Arun District Council
Arun Civic Centre
Maltravers Road
Littlehampton
West Sussex BN17 5LF
Planning & Building Control General Enquiries
Tel: (01903) 737756 Fax: (01903) 730442
Dx: 57406 Littlehampton
Minicom: 01903 732765
e-mail: planning@arun.gov.uk
website: www.arun.gov.uk/planning

Application No: Y/13/21/HH
Site Address: Old Barn House Hoe Lane Flansham PO22 8NT
Description of works: Conversion of an existing detached carport with room above into an additional self contained dwelling ancillary to the main dwelling, removal of front window to main house & installation of bifolding doors.

Thank you for your internet representation made on 21st April 2021 which has been recorded as no objection with the comments as follows:

Drawing No. Drawing Name:
01013 Proposed Elevations

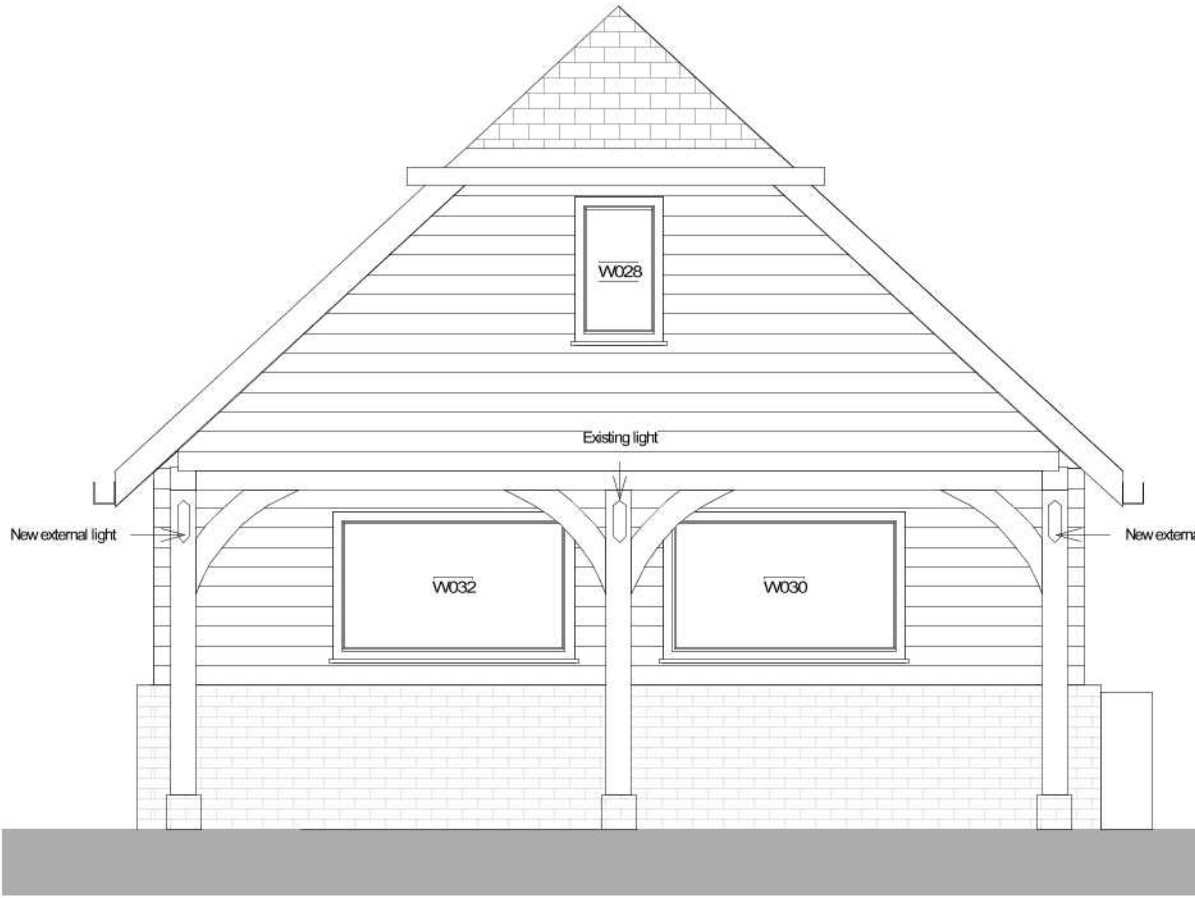
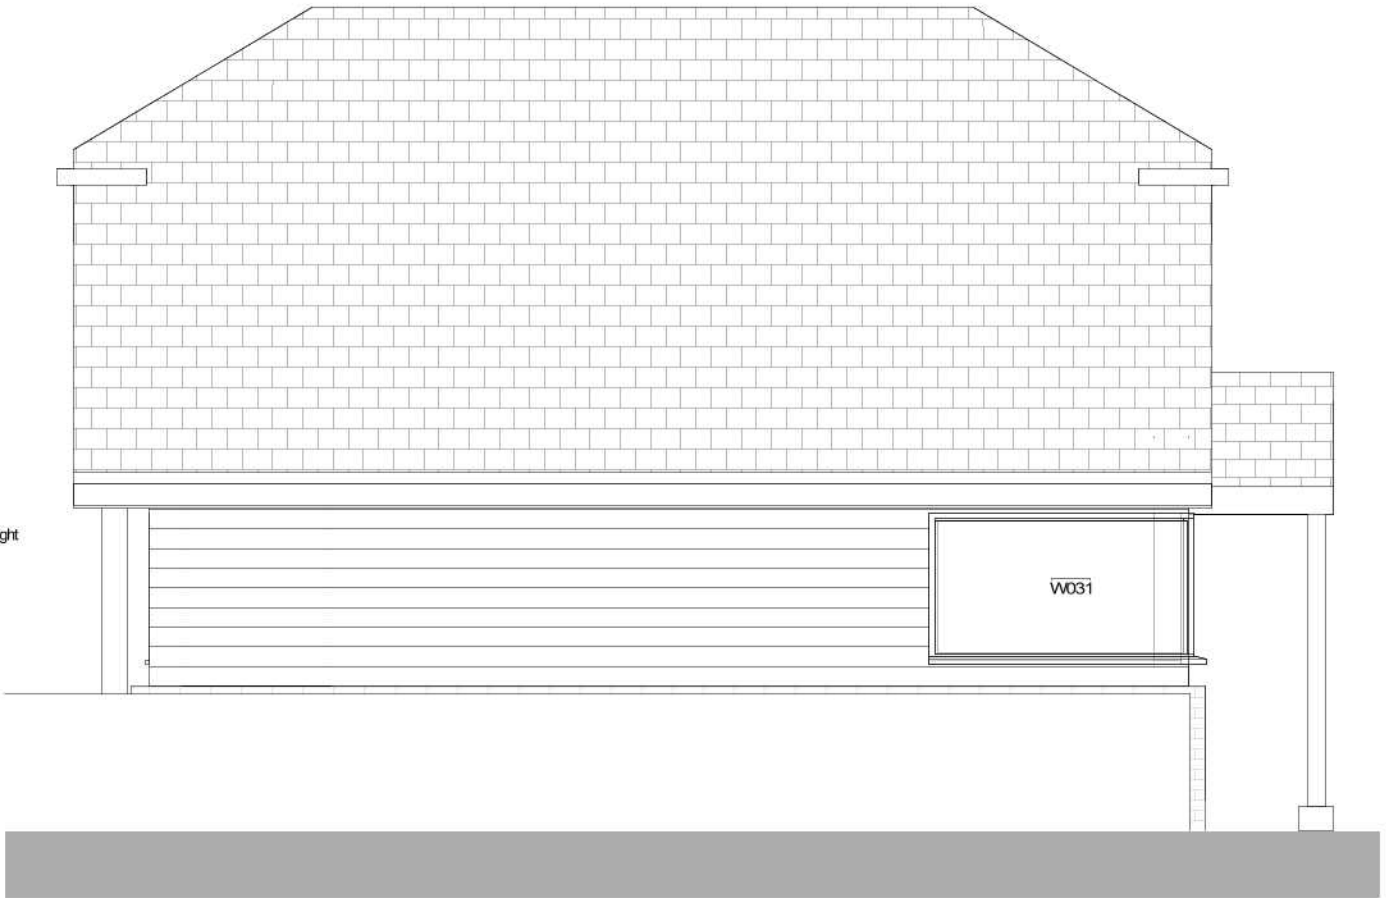
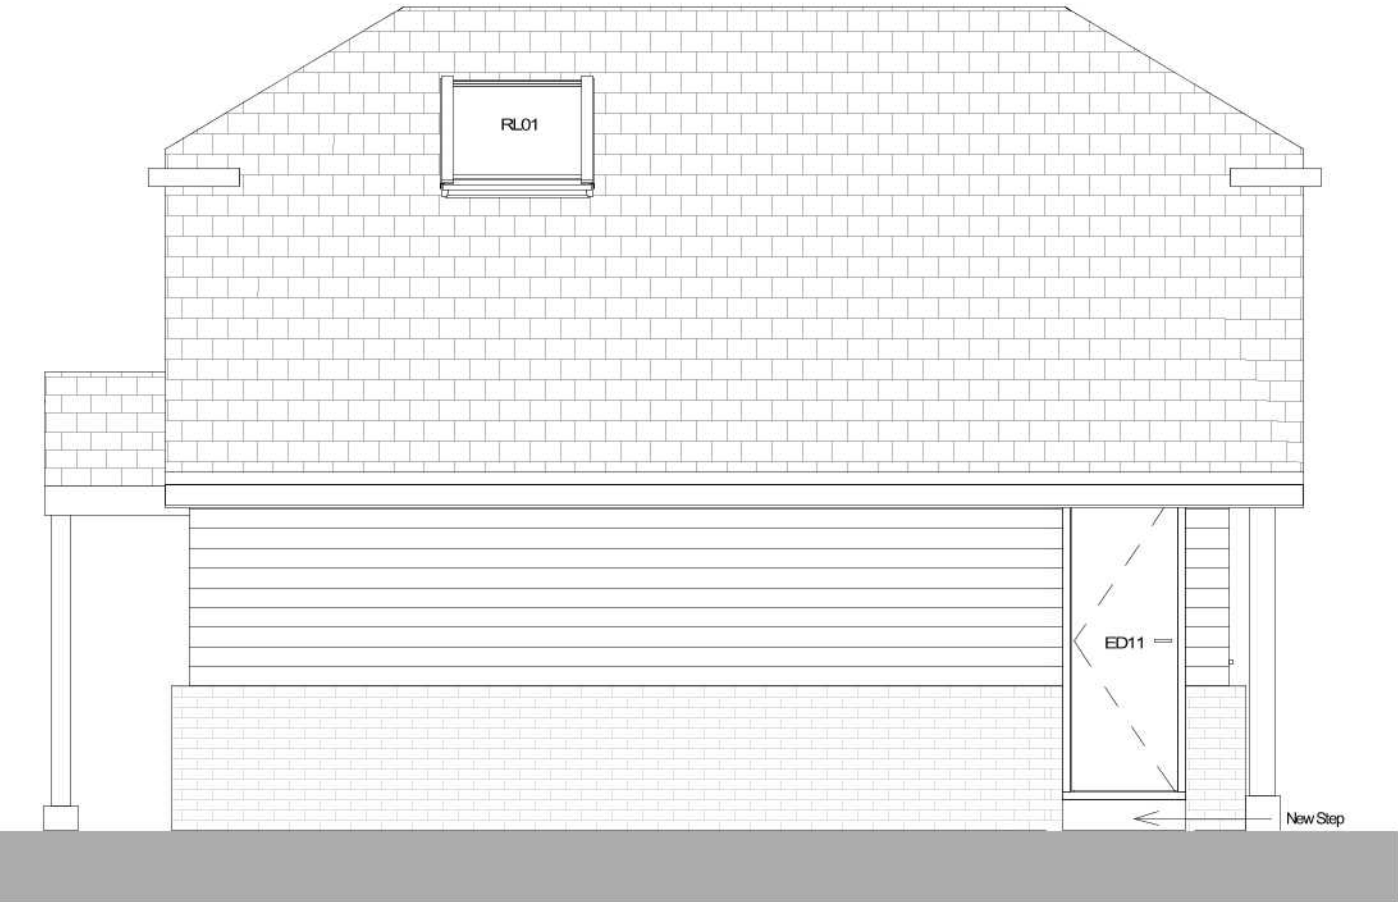
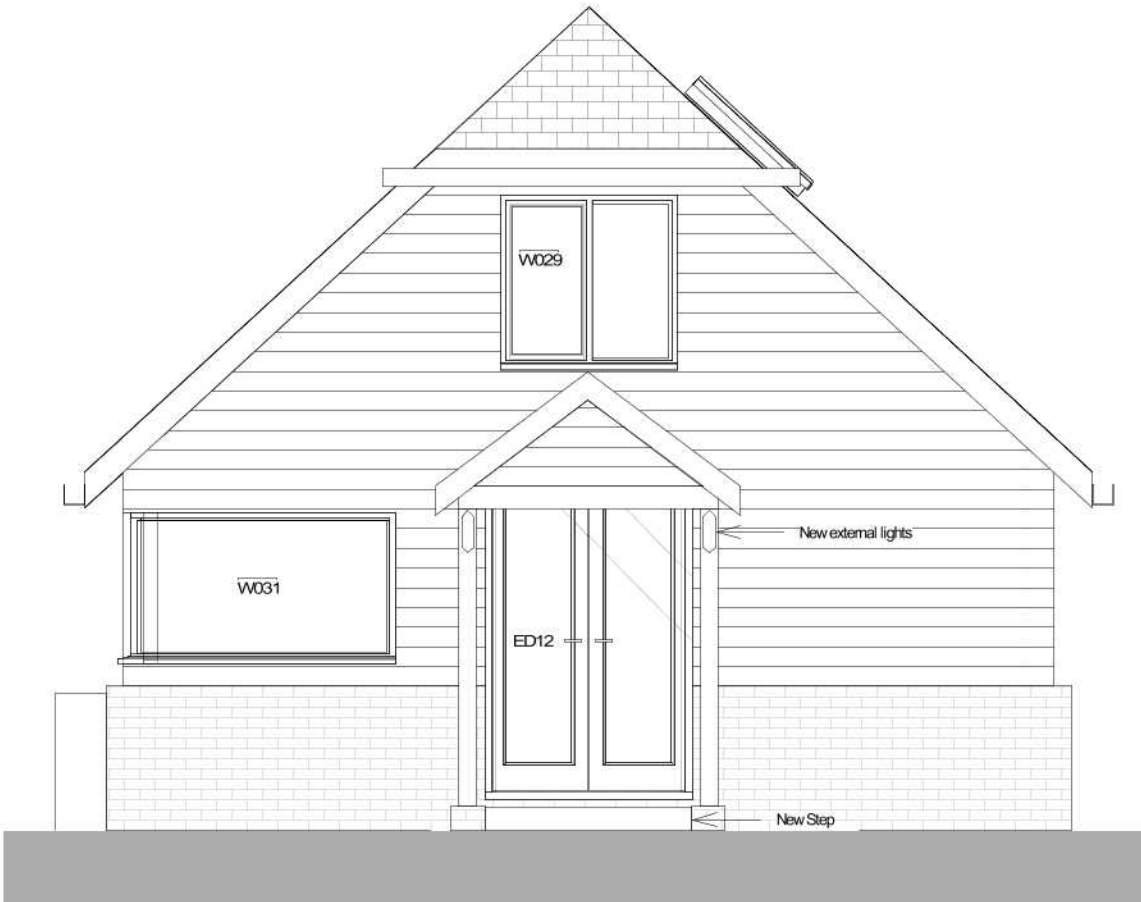
- sufficient parking provision is in place before occupation for both the existing main residential premises as well as the proposed ancillary accommodation.
- YPC would also seek that the design of the proposed windows within the proposed unit are revised to ensure that they are in keeping with the nature of the building and area.
- A condition restricts the use of the unit to ancillary accommodation only to the main residence.
